CITY OF ALBUQUERQUE

PLANNING DEPARTMENT – Development Review Services

**Re: Hydraulic Analysis Addendum to the Amendment to the DMP Trails Units 1,2,
and 3
Drainage Report, Engineer's Stamp Date 10-22-2014 (File: C09D001)**

City Project No. 730084 Zone Map No. C-9-Z Sheet 19 of 51

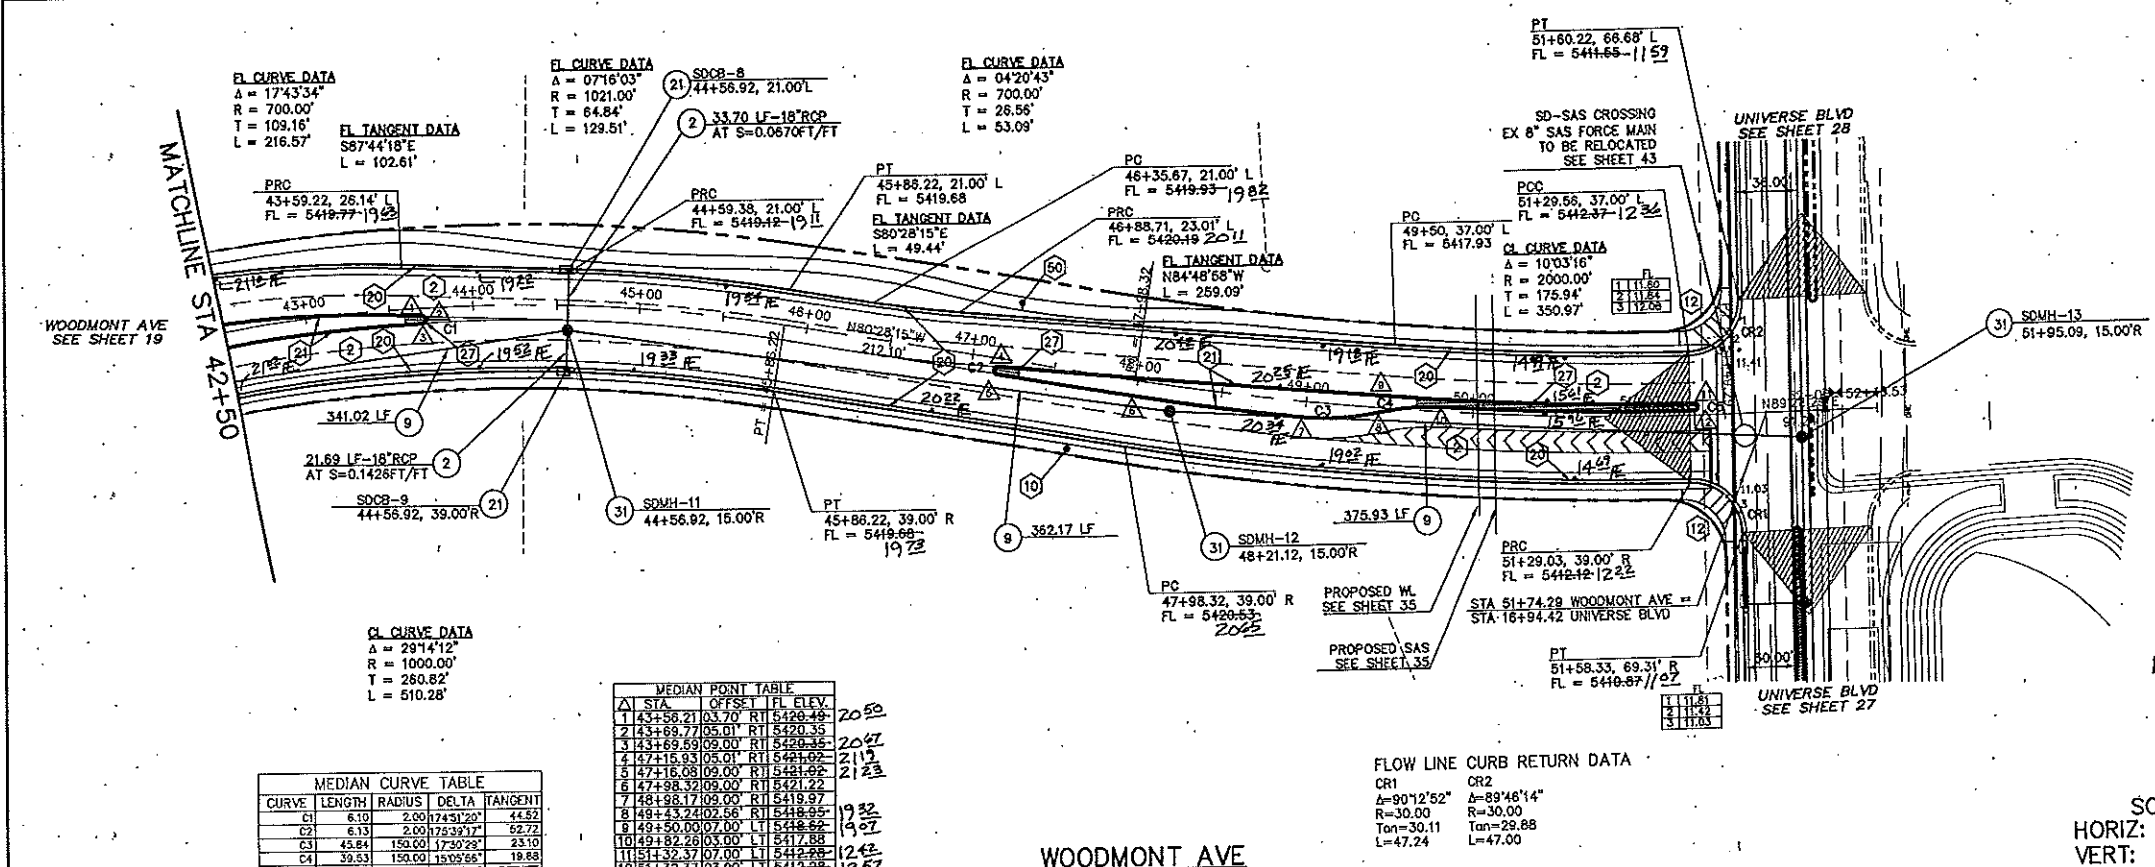
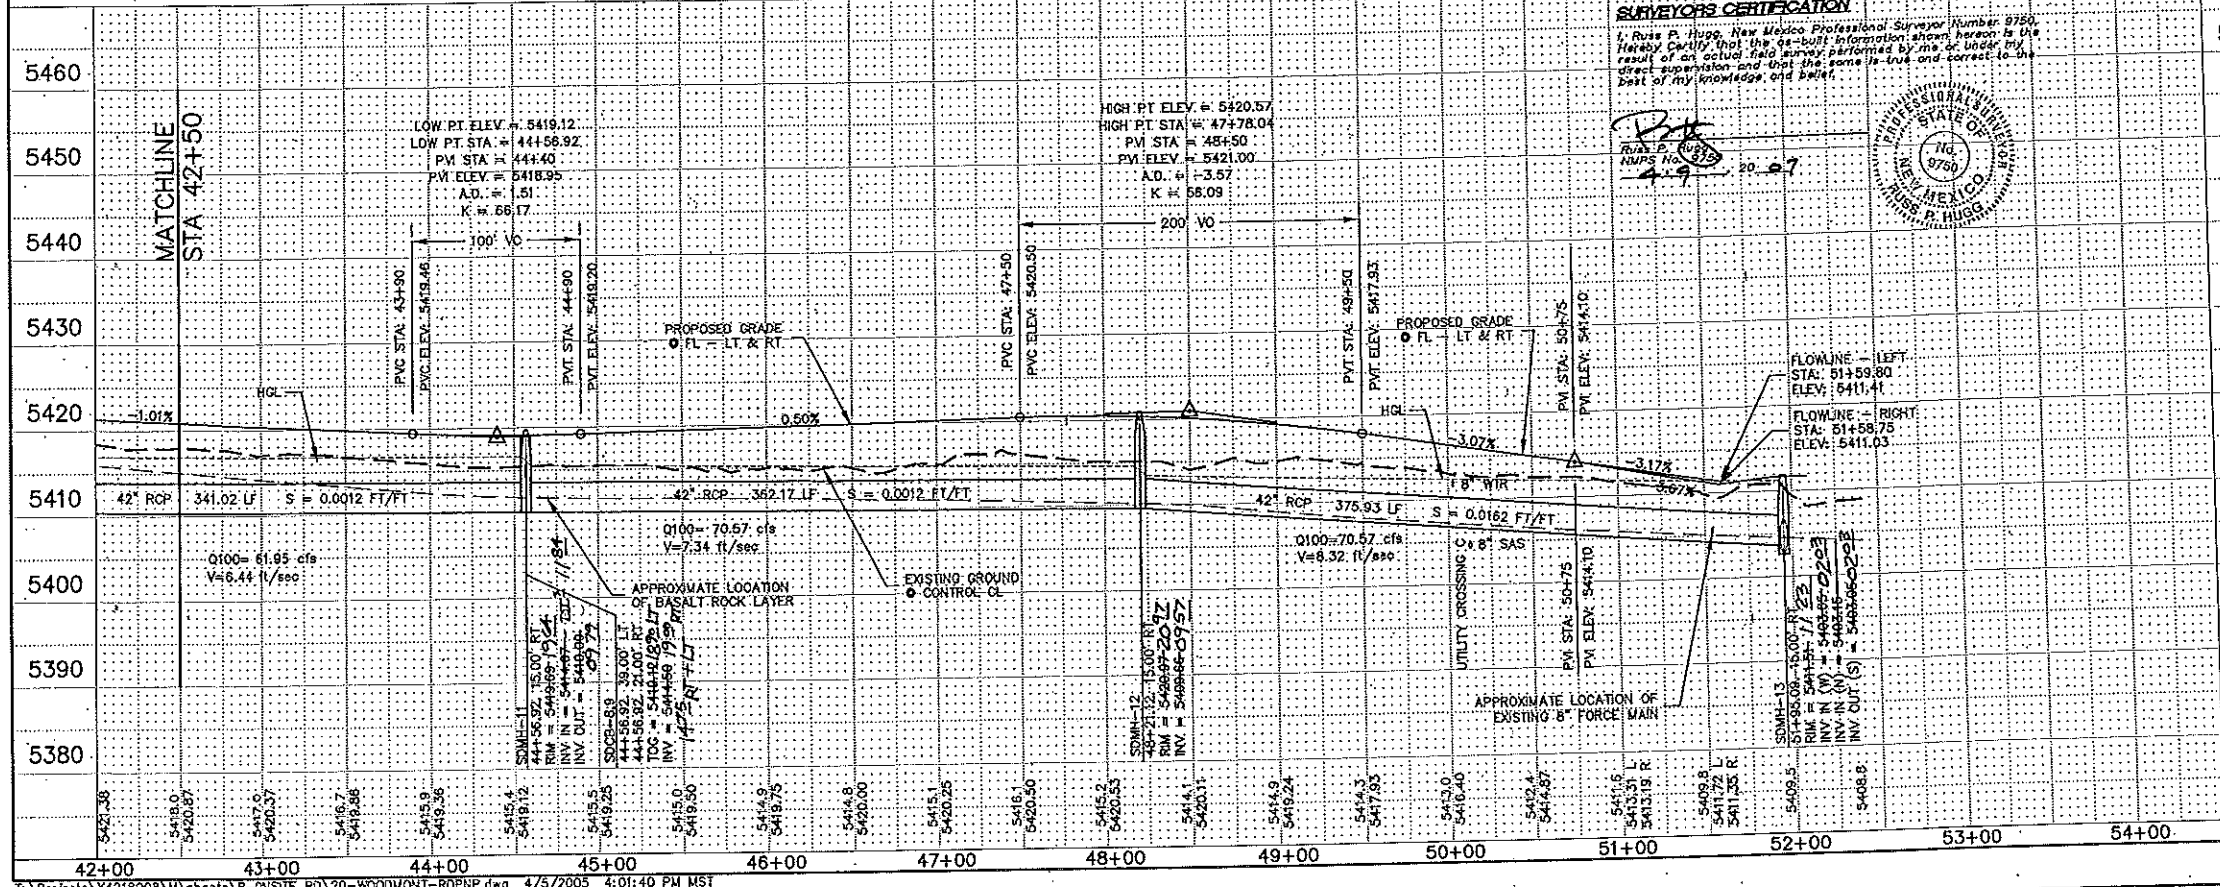
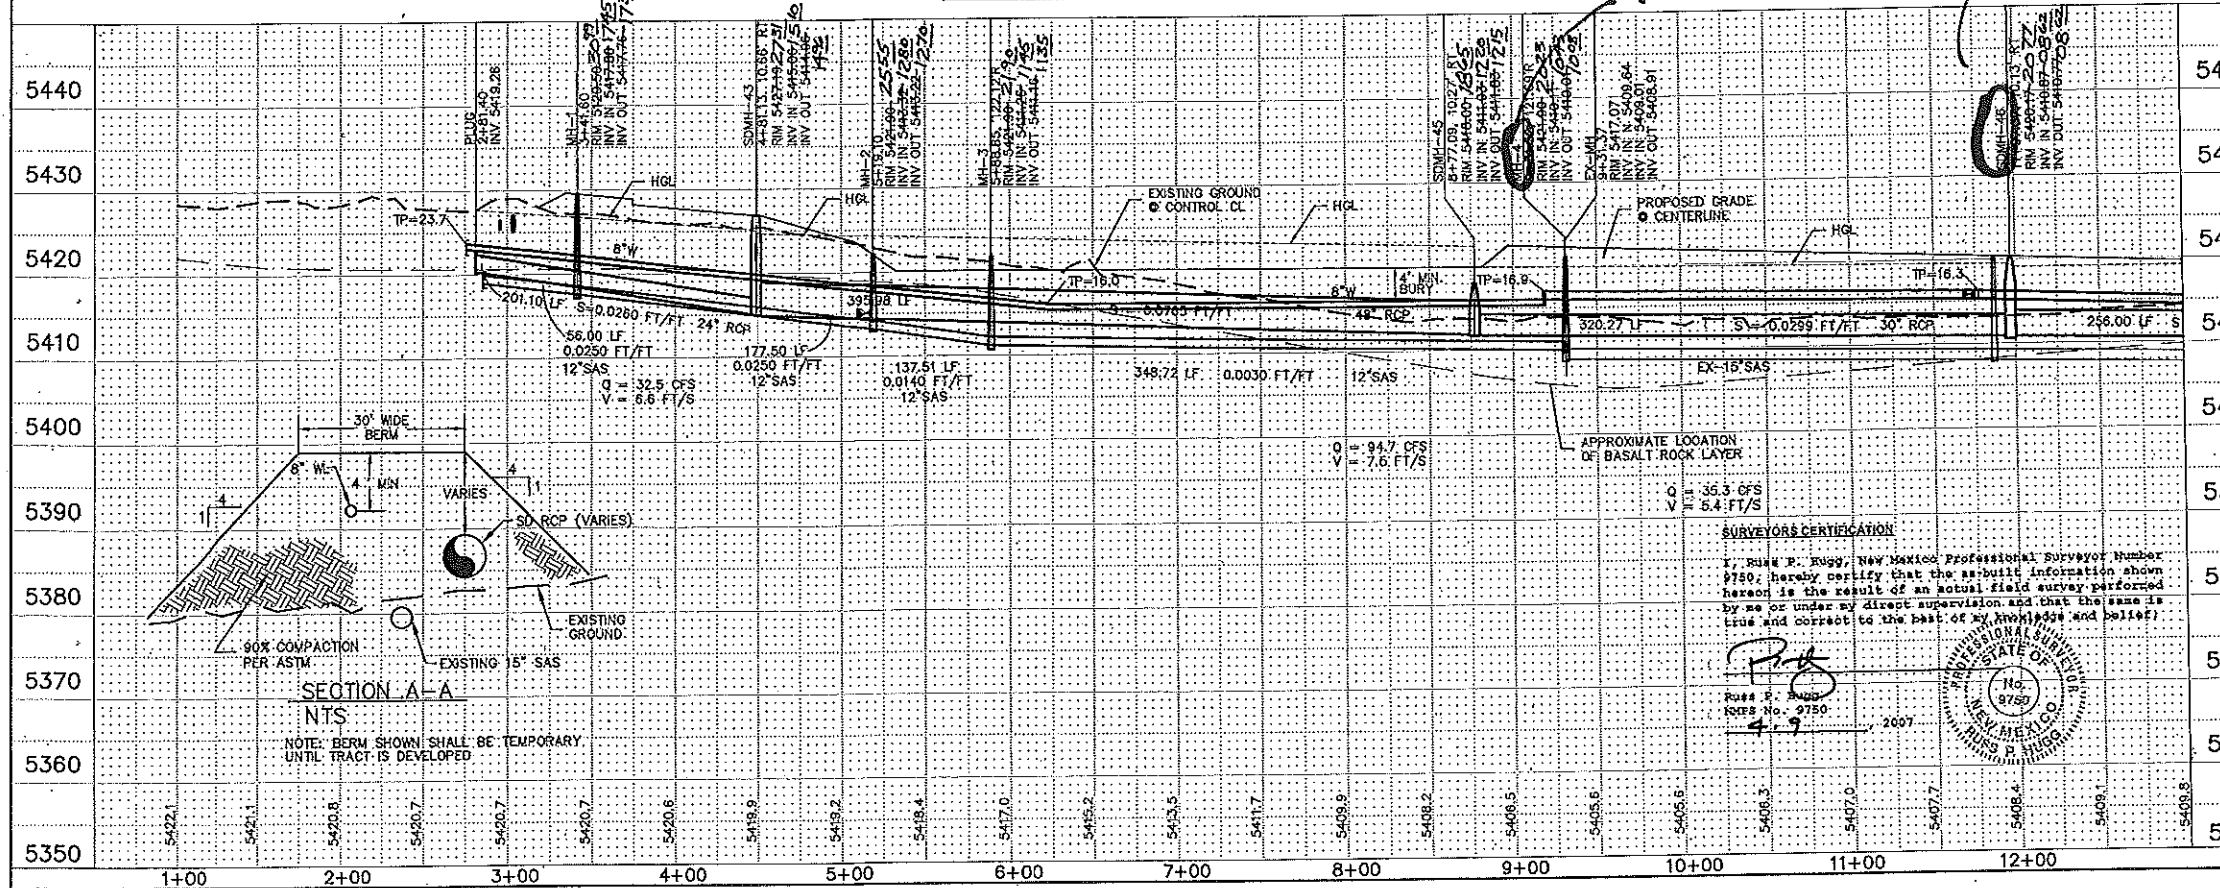
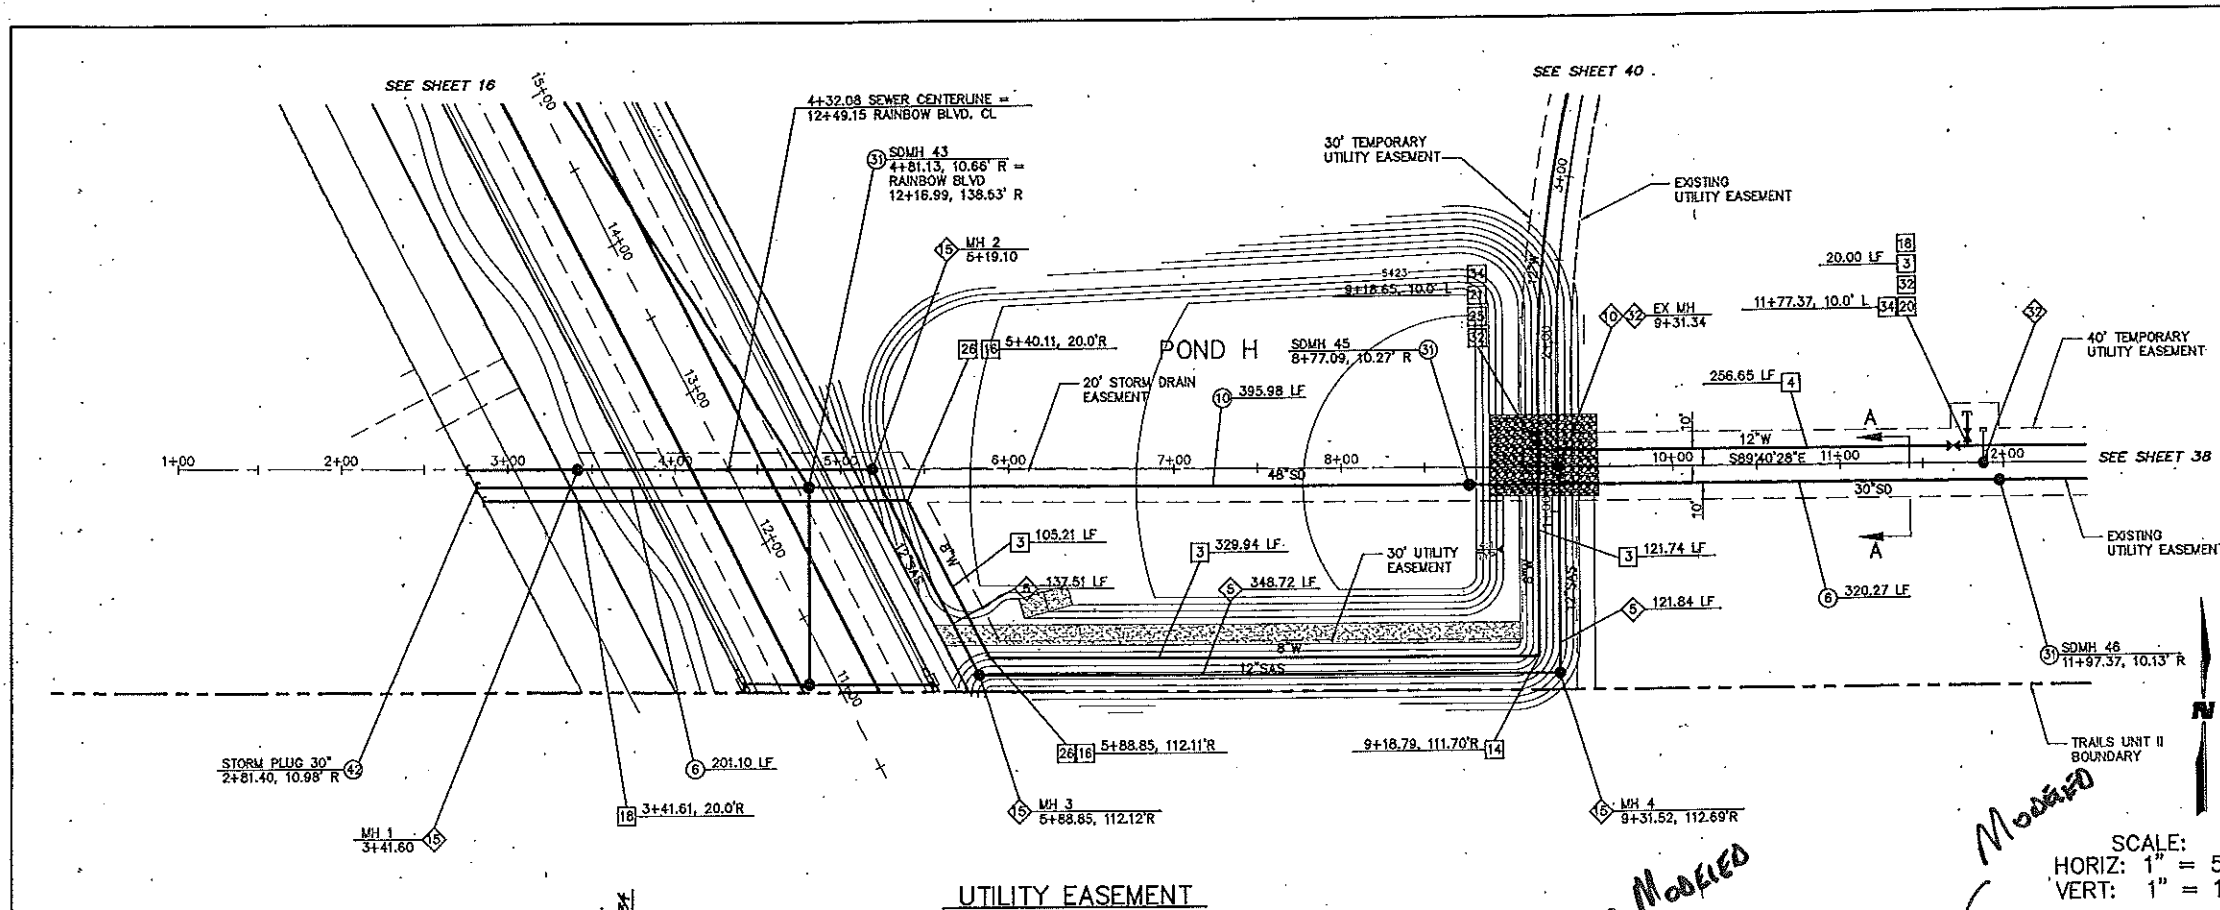
- Link L-13: D/S Invert is 5403.05 (the design value) but the As-built value is 5402.03 per CPN 730084 Sheet 20/51 for a difference of 1'. The HGL is 5410.75 and adding 1' makes it 5412. The Rim is 5411.23, so the HGL is above the Rim.
- The Links from pond G to Universe have a significantly different Hydrograph when comparing the Base to Scenario 1. Can you explain why?
- Link L-24 and Link 180 discharge into Pond G through slotted manholes. Are the areas of the slotted manholes taken into account? If not, the required opening area needs to be stated on Table 3 as part of the improvements to Pond G (or any pond with slotted manholes).
- Verify negative peak flows in Links L-27 and L-29 make sense. Time of Peak Velocity for Link L-27 is 37.2, why so much later?
